Application H11-1007-21
Location Adderley House, Stable Block 23 London Road Long Sutton PE12 9EA
Proposal Change of Use of existing barn into two dwellings including extension

Name Greg Watkinson
Address Conservation Officer

DWG TITLE :
Proposed Site Plan

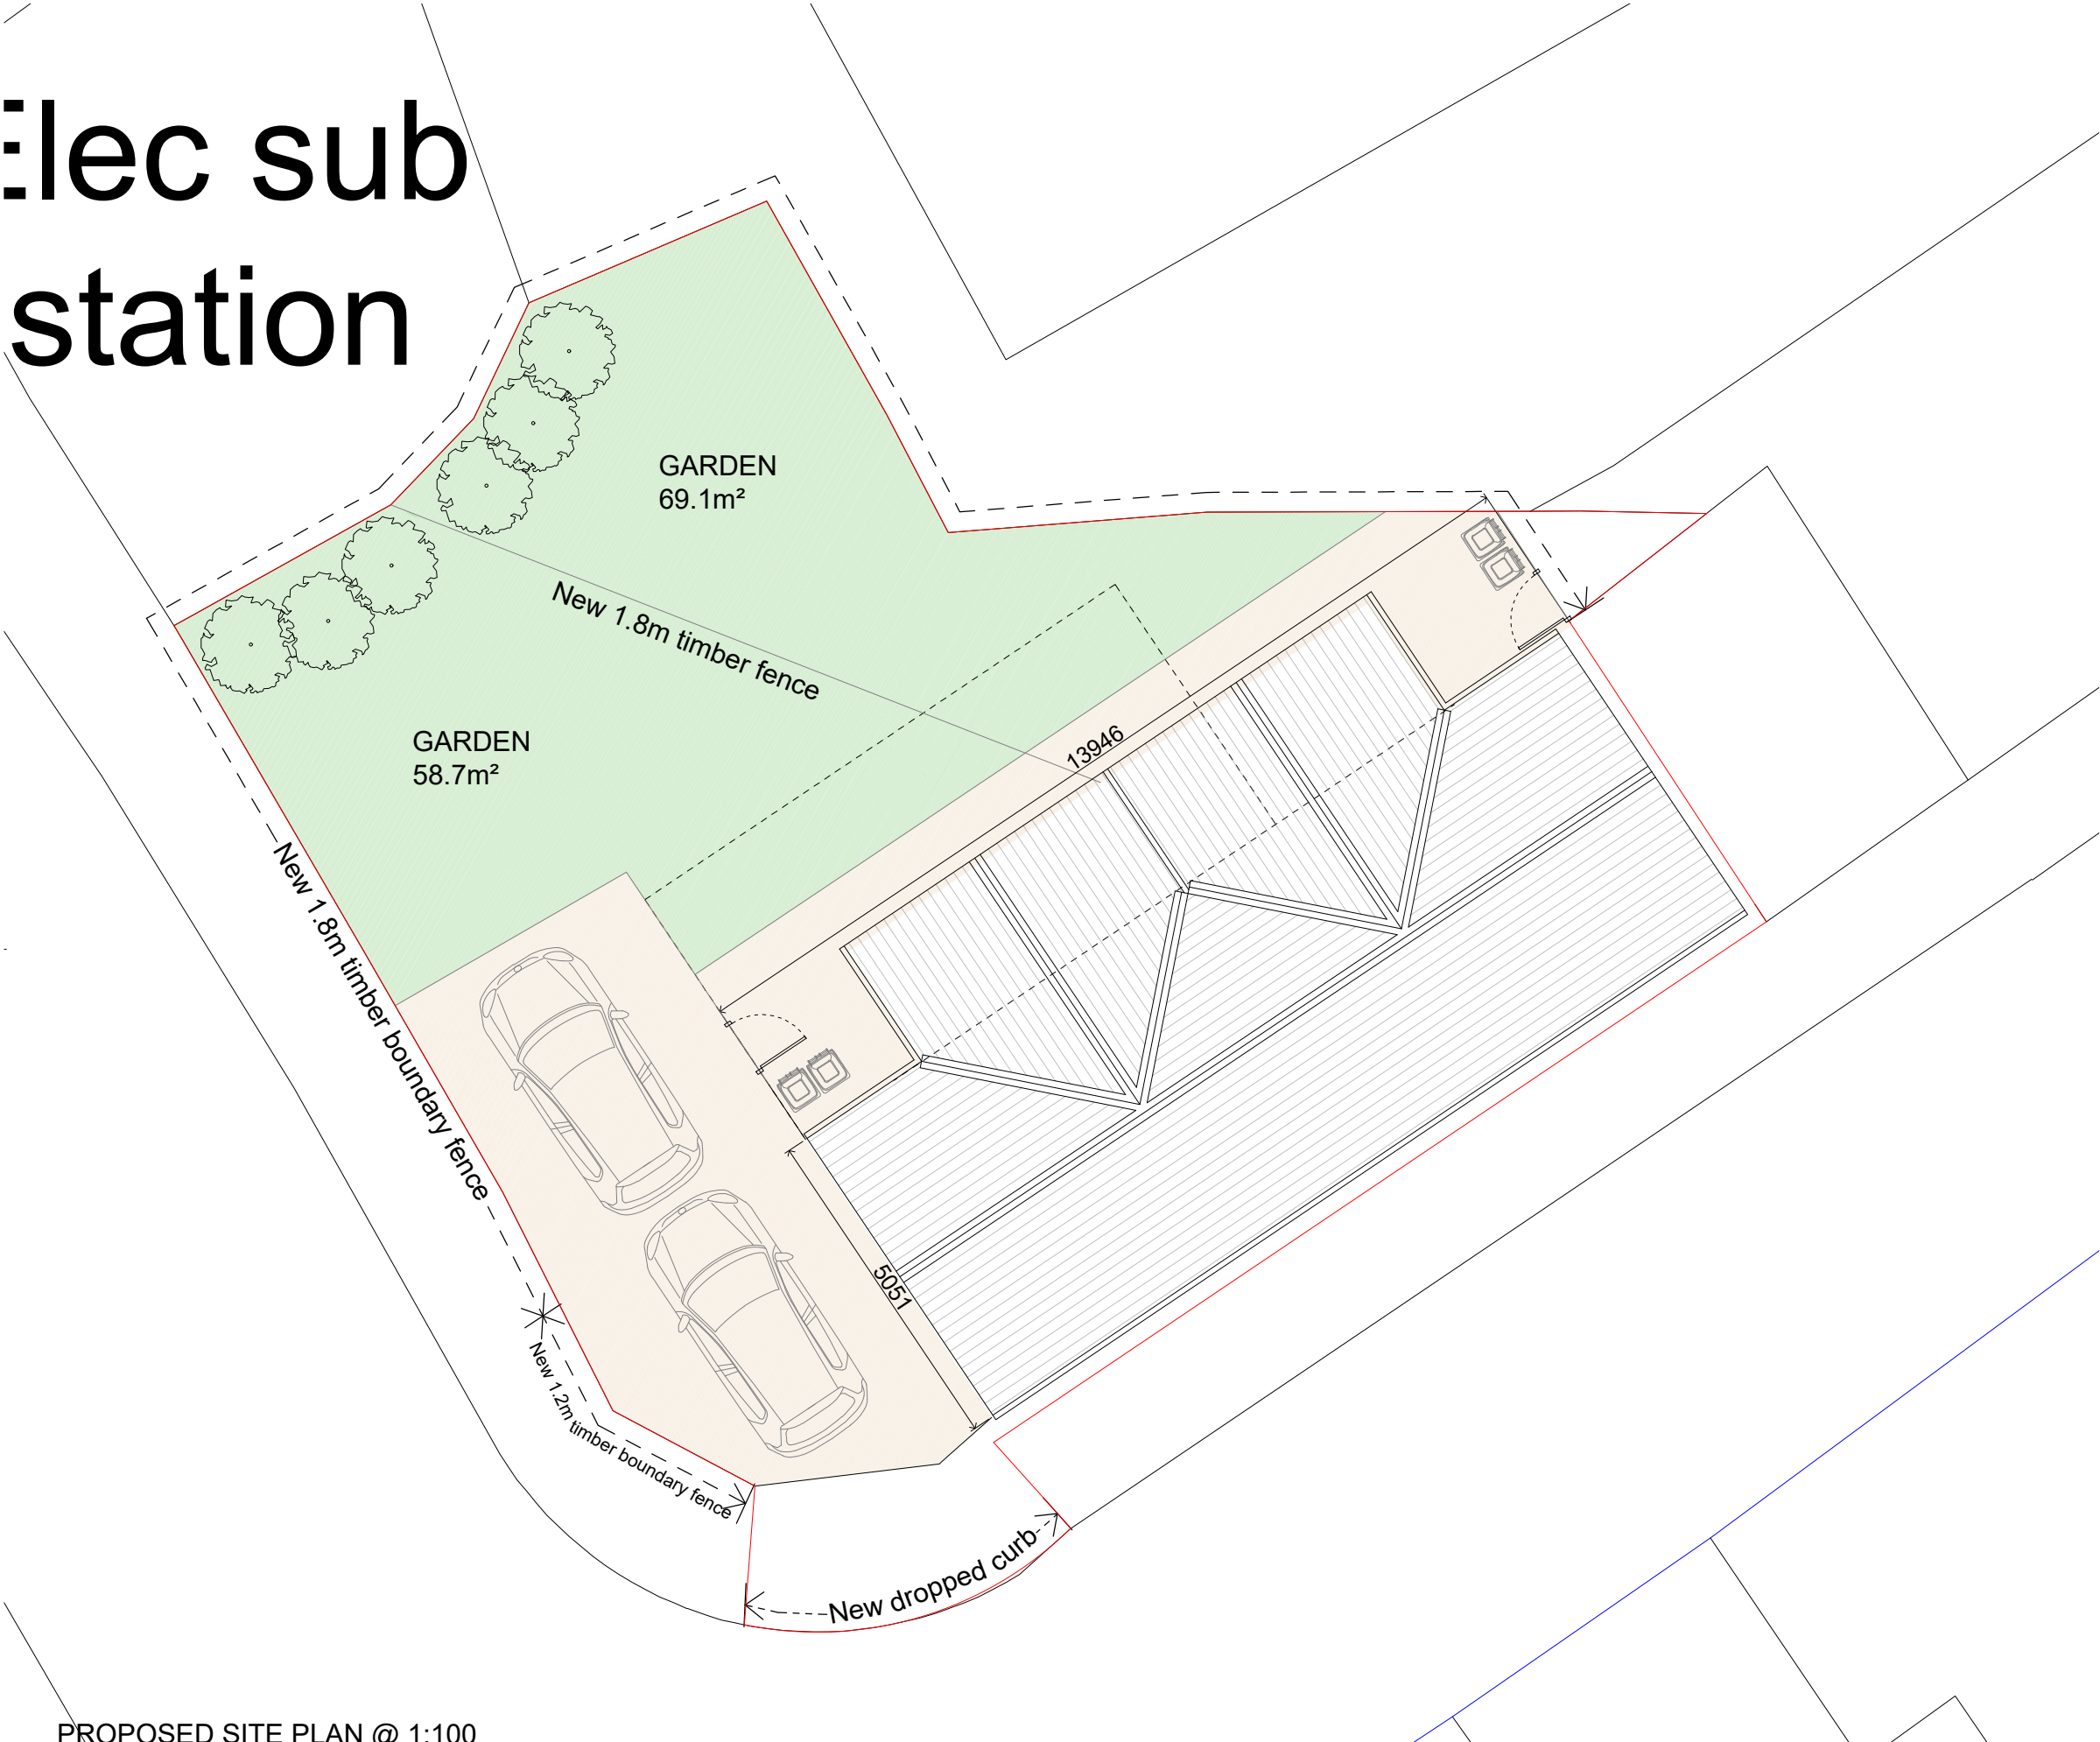
I have concerns with this development as proposed. As this is a listed property, it is important that any development is respectful to the host property and its setting, and as such should be of a reasonable scale. The principle of converting this site into residential use is a sound one, however, the proposed rear extensions are very large in terms of scale, massing, and particularly height when compared to the original structure, and therefore would be harmful to the value and significance of the heritage asset by way of overdeveloping the structure and causing the original structure to appear diminutive in comparison. The design of these extensions is also void of any sort of character or respect to the listed structure and would lead to an extension that appeared to be a modern, featureless, and completely out-of-keeping addition to this historic property.

I would suggest that a single-storey rear extension, in place of the extant single-storey lean-to would be a more appropriate scale of development. Furthermore, the design of such an extension should be fully commensurate with and respectful of the historic and listed nature of the building, and therefore should be of exceptionally high quality, making use of appropriate/sensitive materials, as well as architectural styles and features.

In its current state, I cannot support a recommendation of approval for this application.
